Application No: AW/35/22/HH
Site Address: 49 The Drive Aldwick PO21 4DS
Description of works: Erection of single storey rear extension and conversion of loft to habitable use following the demolition of existing rear conservatory.

Thank you for your internet representation made on 2nd March 2022 which has been recorded as an objection with the comments as follows:

4 North (Rear) Elevation Proposed
1 : 100

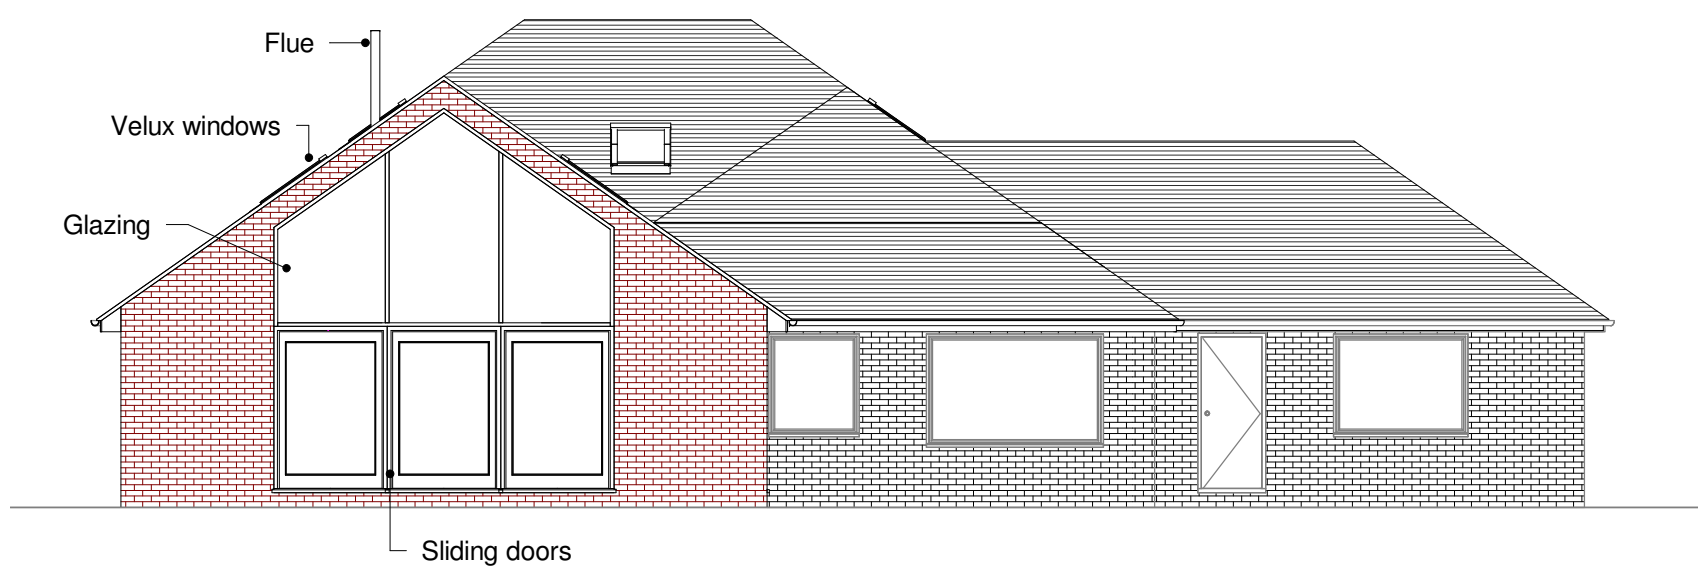
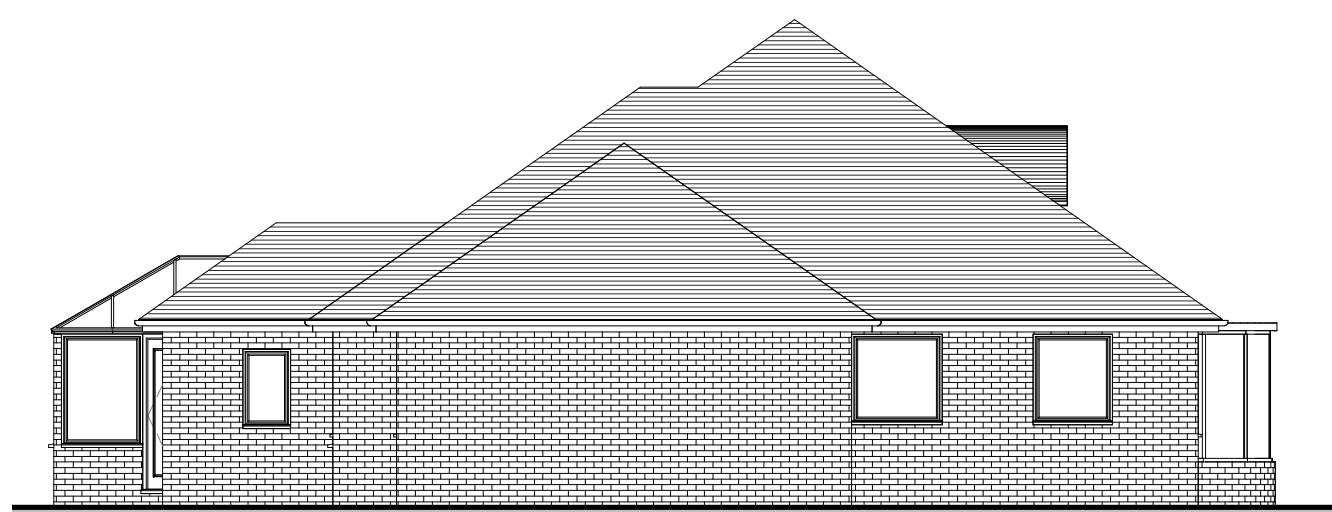
The vast height and breadth of these north elevations give external views from the property over the gardens and rear rooms to the north of the site, especially Nos.40,40A and 42 Kingsway. The position of this rear, fully glazed elevation is further north than the existing building and for such a cramped back garden, emphasizes the closeness to the Kingsway properties. At present there is NO overlooking, so there is a material change in these proposals, enlarging the footprint north of the property with the result that overlooking etc are introduced.

7 East (Side) Elevation Existing
1 : 100

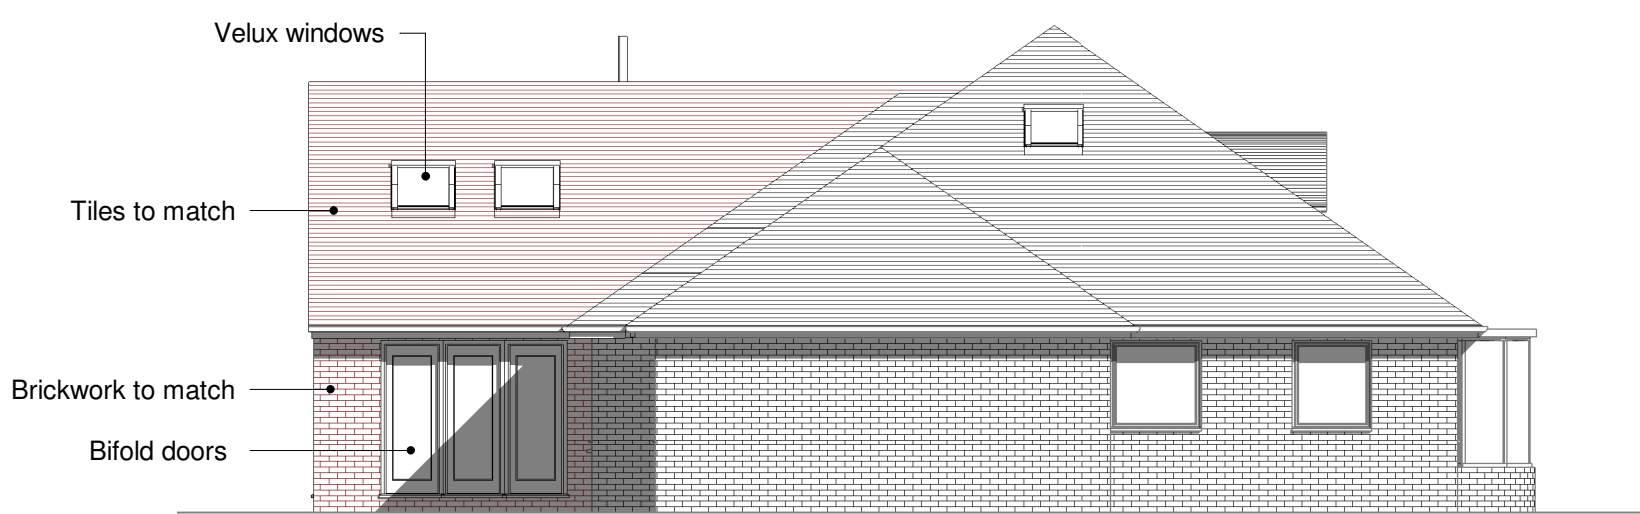
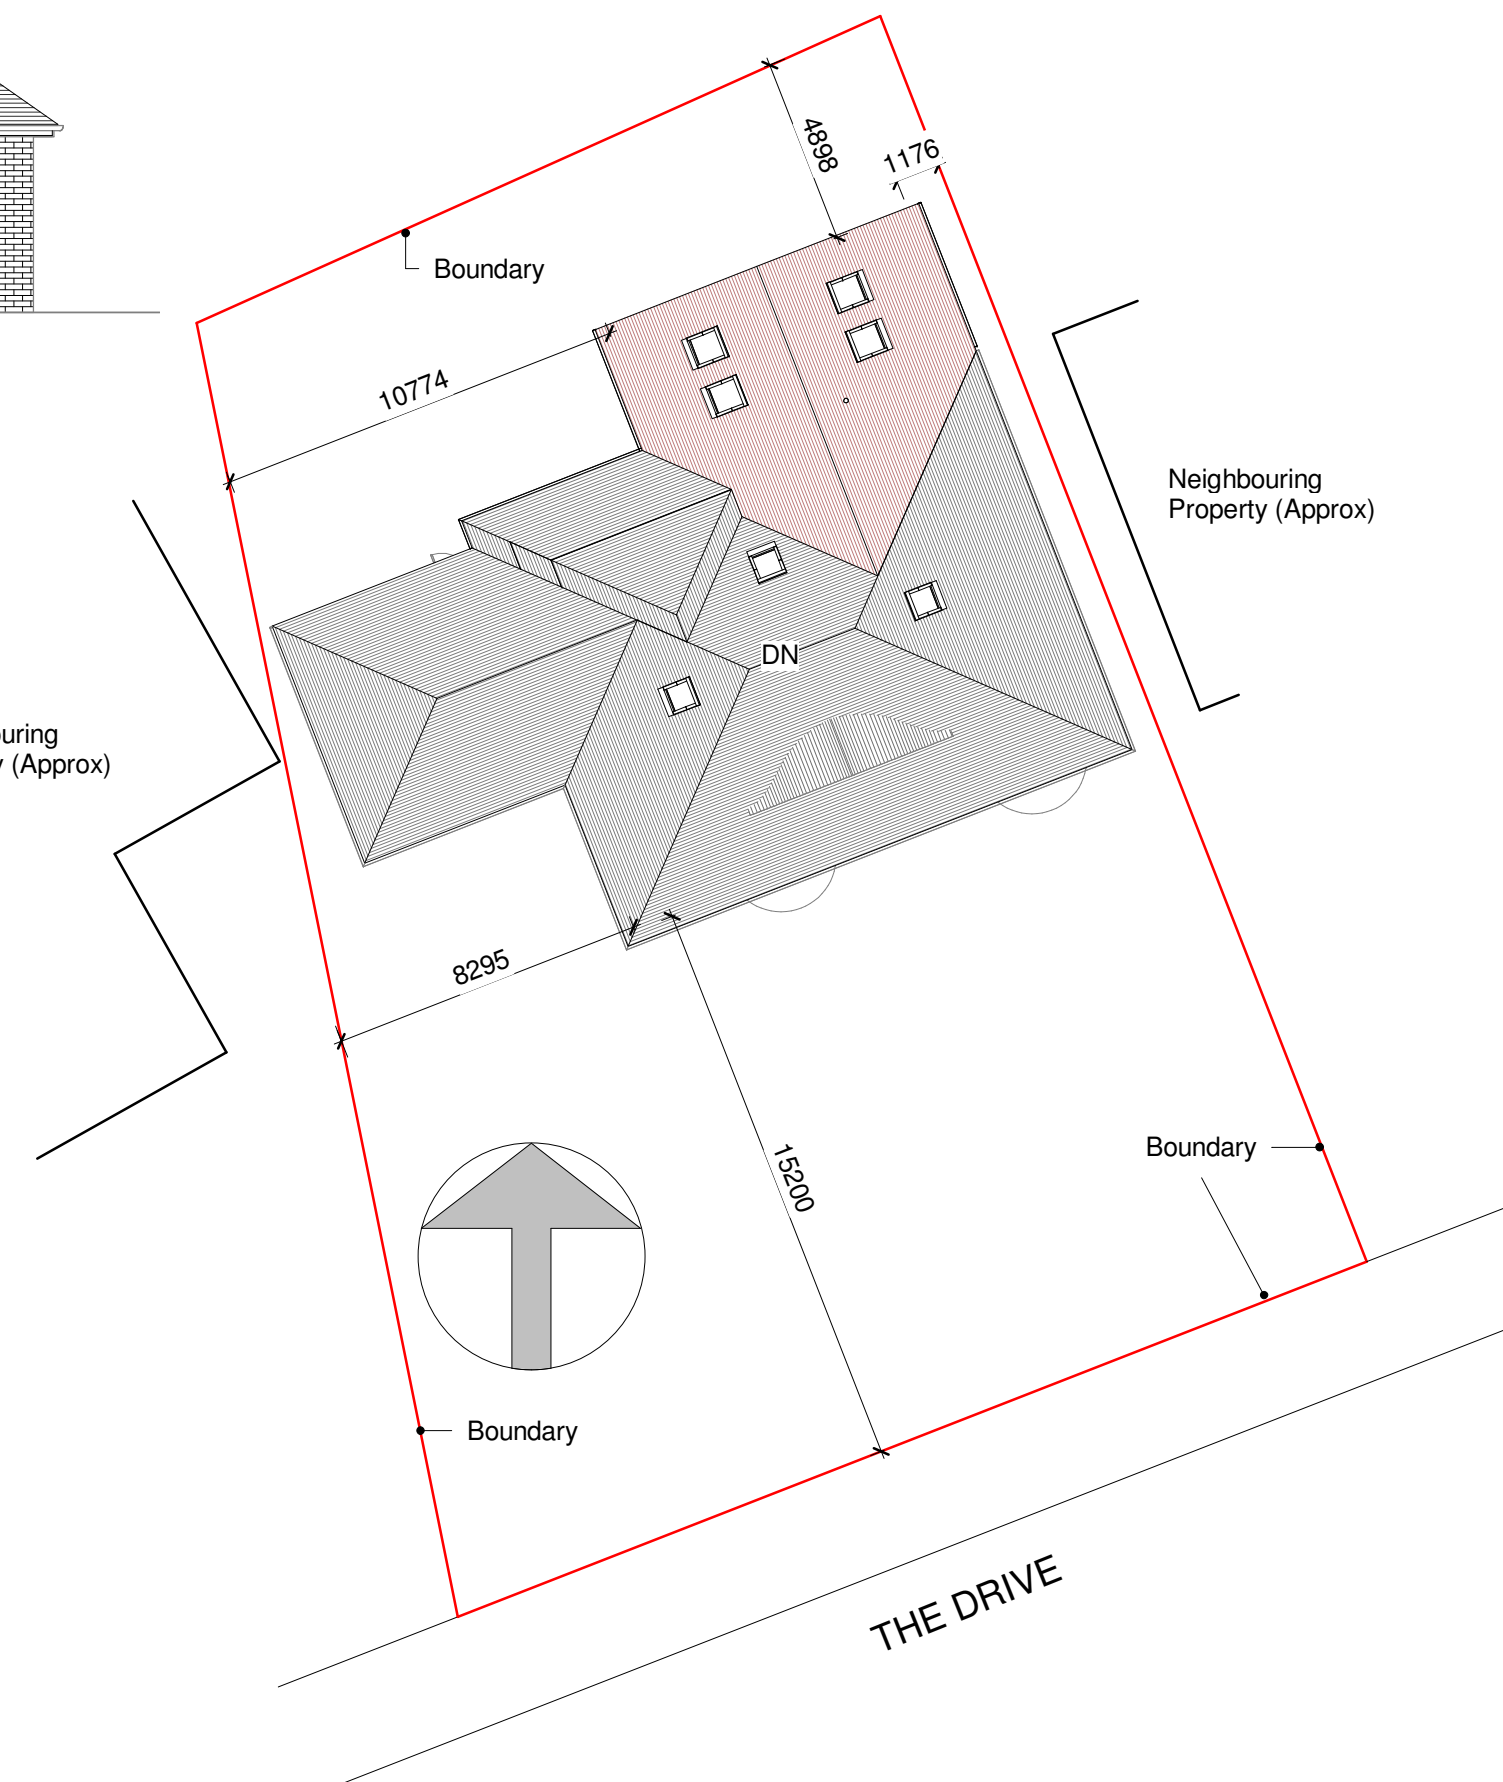
Similarly, external views from The Drive east and west of the site will mean that although there is technically not a great increase in height in the proposals, enlarging the footprint and inserting the upper floor extension will result in overlooking etc.

Similarly, external views from The Drive east and west at this point will mean that although there is not a big increase in height, the views will greatly encroach, by the very bulk of the side walls of the upper floor and therefore the street scene along The Drive both east and west affected to their detriment. There is no positive contribution to those street scenes, indeed it will be detrimental.
